Ref: D2017/094379

Kate Masters
Senior Planning Officer, Waste
Industry Assessments
Department of Planning & Environment
GPO Box 39
Sydney NSW 2001

**Woodlawn Bioreactor Modifications (MP 10_0012 MOD 2 and DA 31-02-99 MOD 3)
Submissions on Modification Application**

ED-1 & 2 Layout & Inferred Leakage

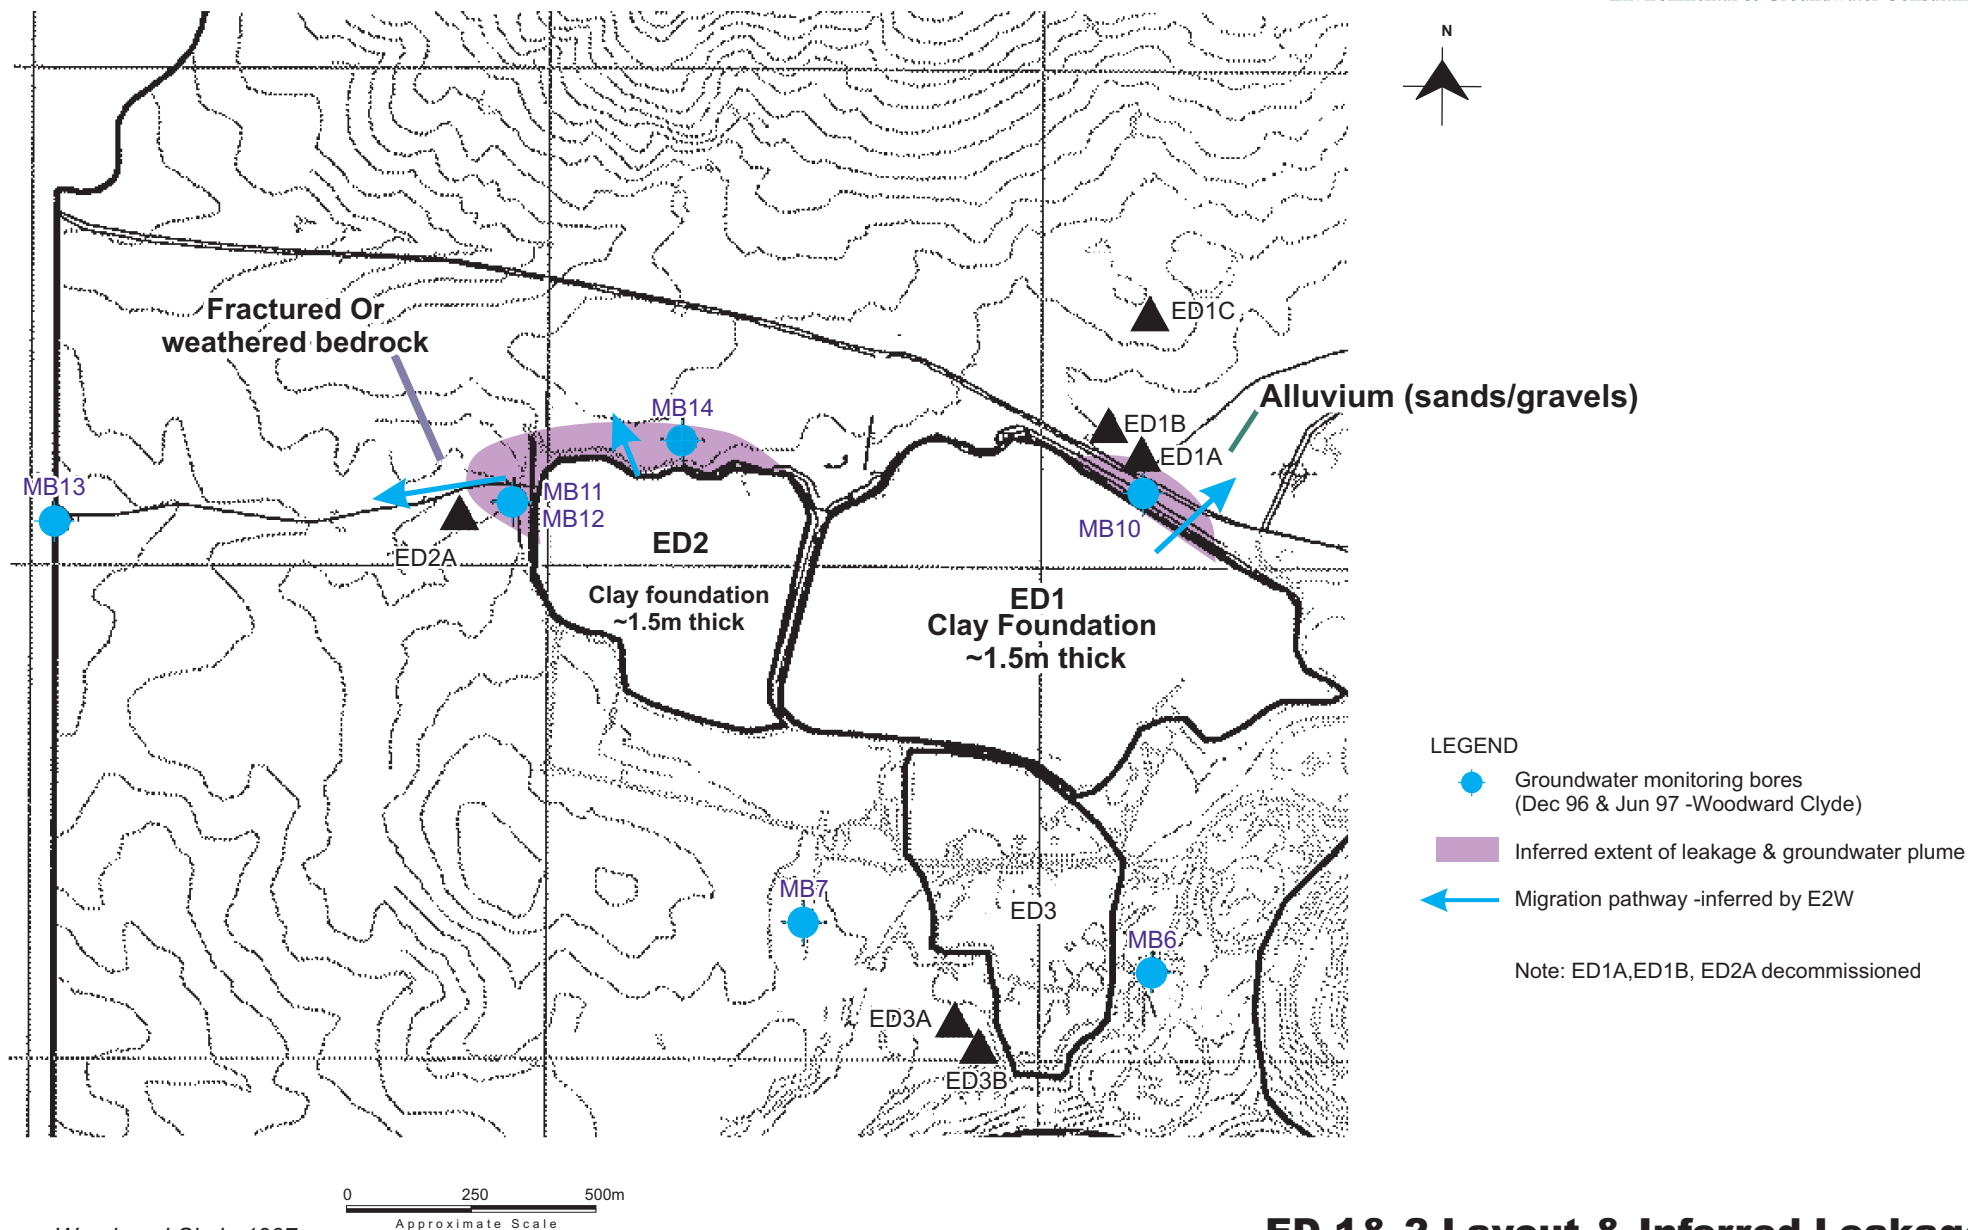
1. If leachate is added to ED1 (without lining of the floor), this will potentially cause treated leachate to seep from the dam. When seepage flows under the Collector Road, although staying within the Woodlawn Eco-Precinct, it potentially leaves the Woodlawn bioreactor Project Site (as defined by the Site EPL and Major Project Consent). This negatively affects the Project's ability to have a neutral or beneficial effect on water quality on the site.

3. Water NSW considers the method to ensure ED1 and ED2 integrity (including any interim dam in ED1) should involve HPDE lining of the evaporation dam floor.

**ED-1 Downstream
Investigation Area**

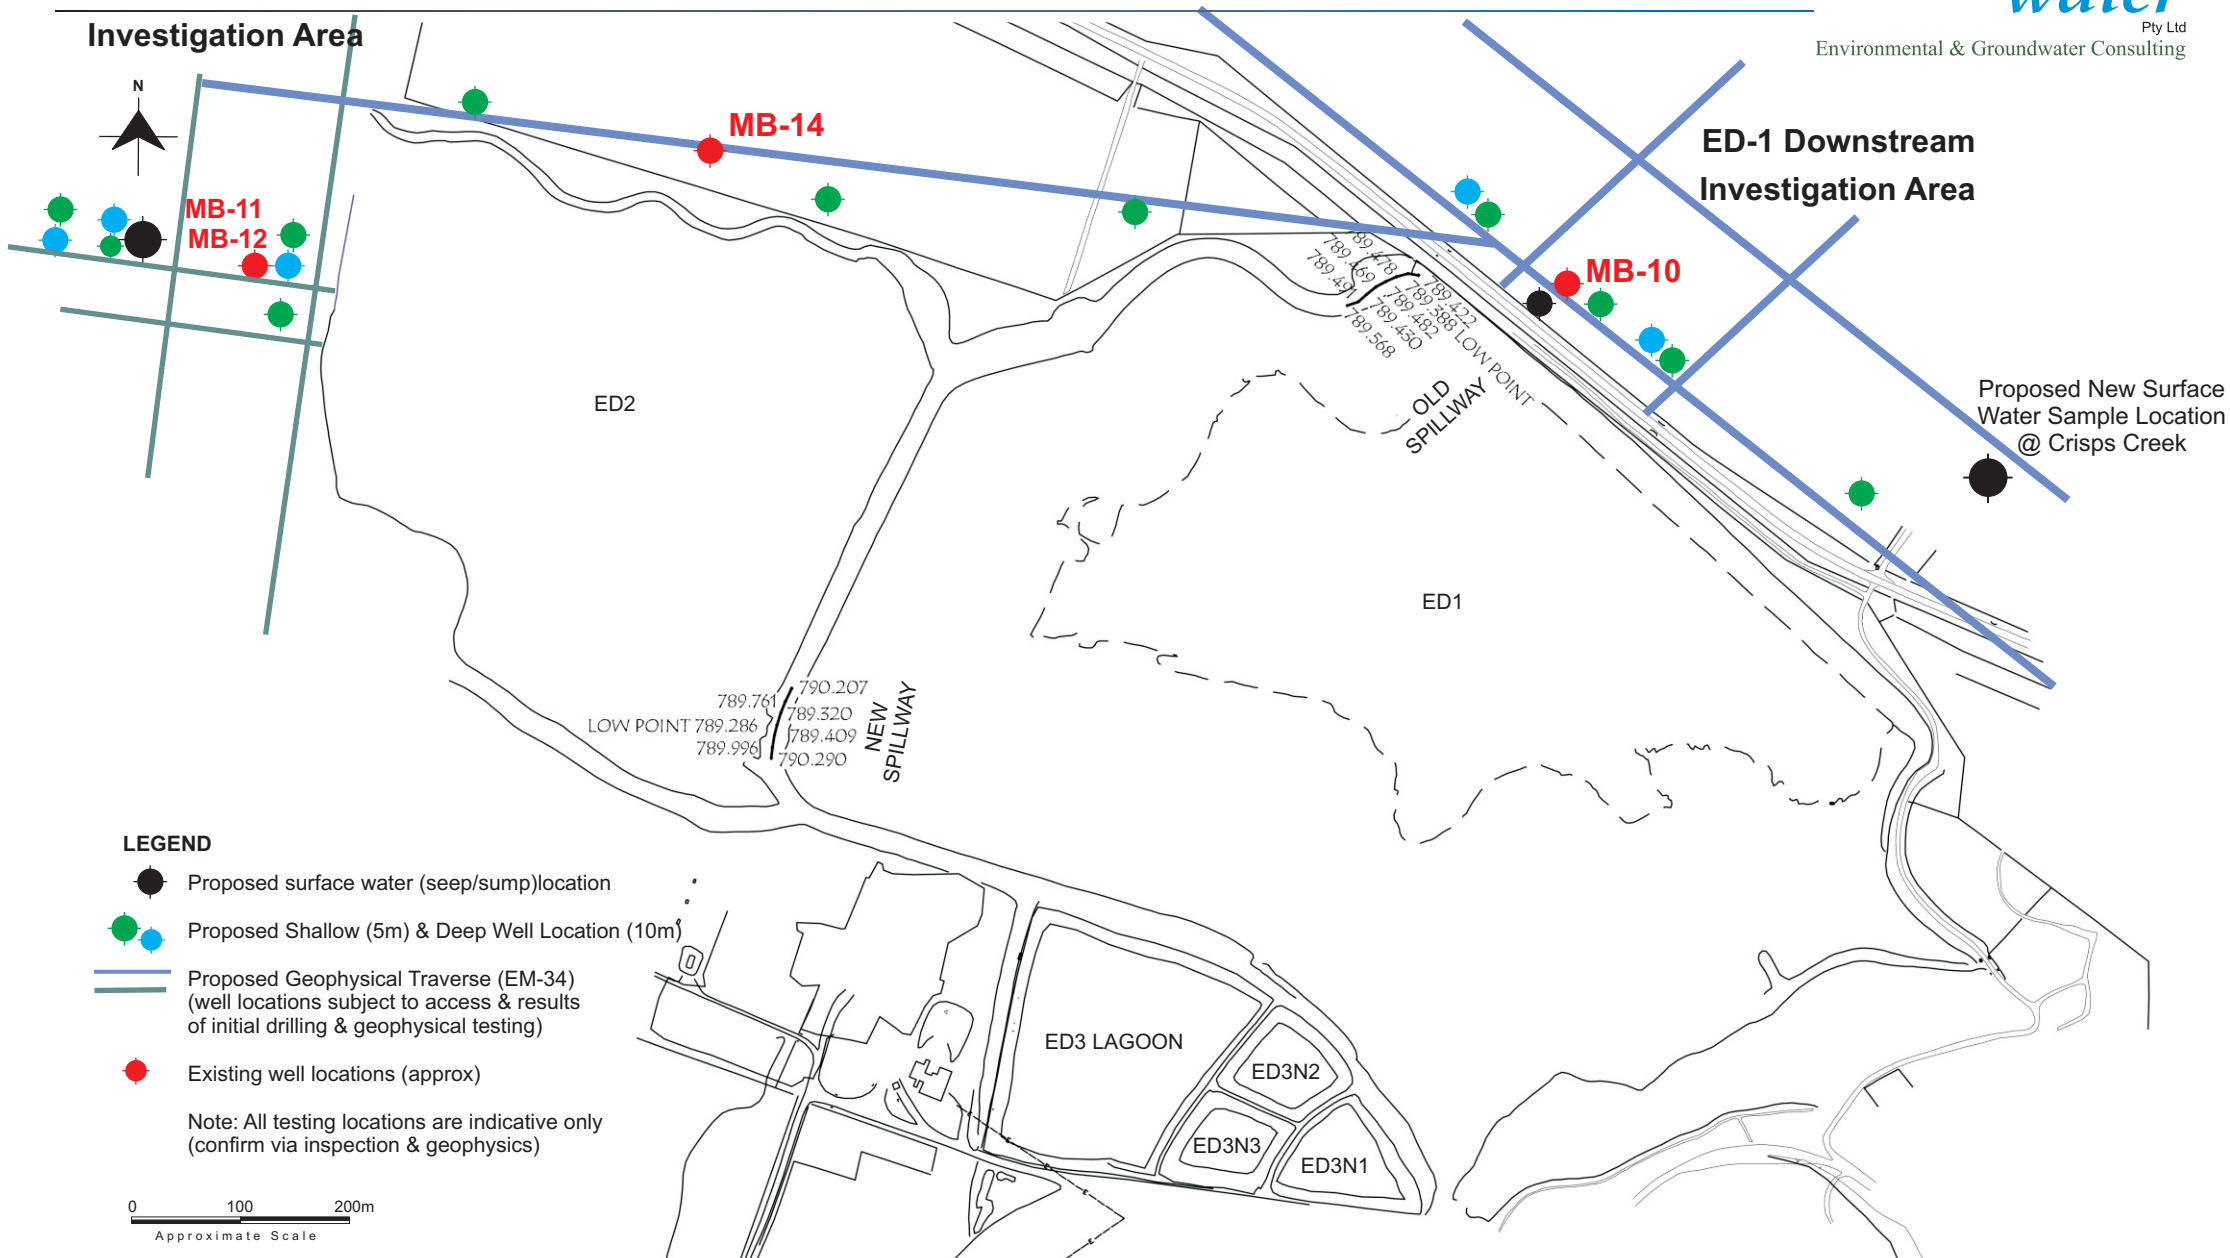
The compatibility between the two assessments, recent AECOM EM survey (dated May 2017) and 2001 EM profiles is not clear. The most recent AECOM analysis shows lower conductivity values in the area south of Crisps Creek, with more elevated levels under Crisps Creek. The 2001 EM survey had a 80 mS/m conductivity contour showing the development of a main plume to the east of the dam (but south of the watercourse), with increased conductivity levels (between 60-80mS/m) near the drainage line. The previous extremity of the 2001 EM survey (1050 metres downstream) appeared further to be further east than the existing works.
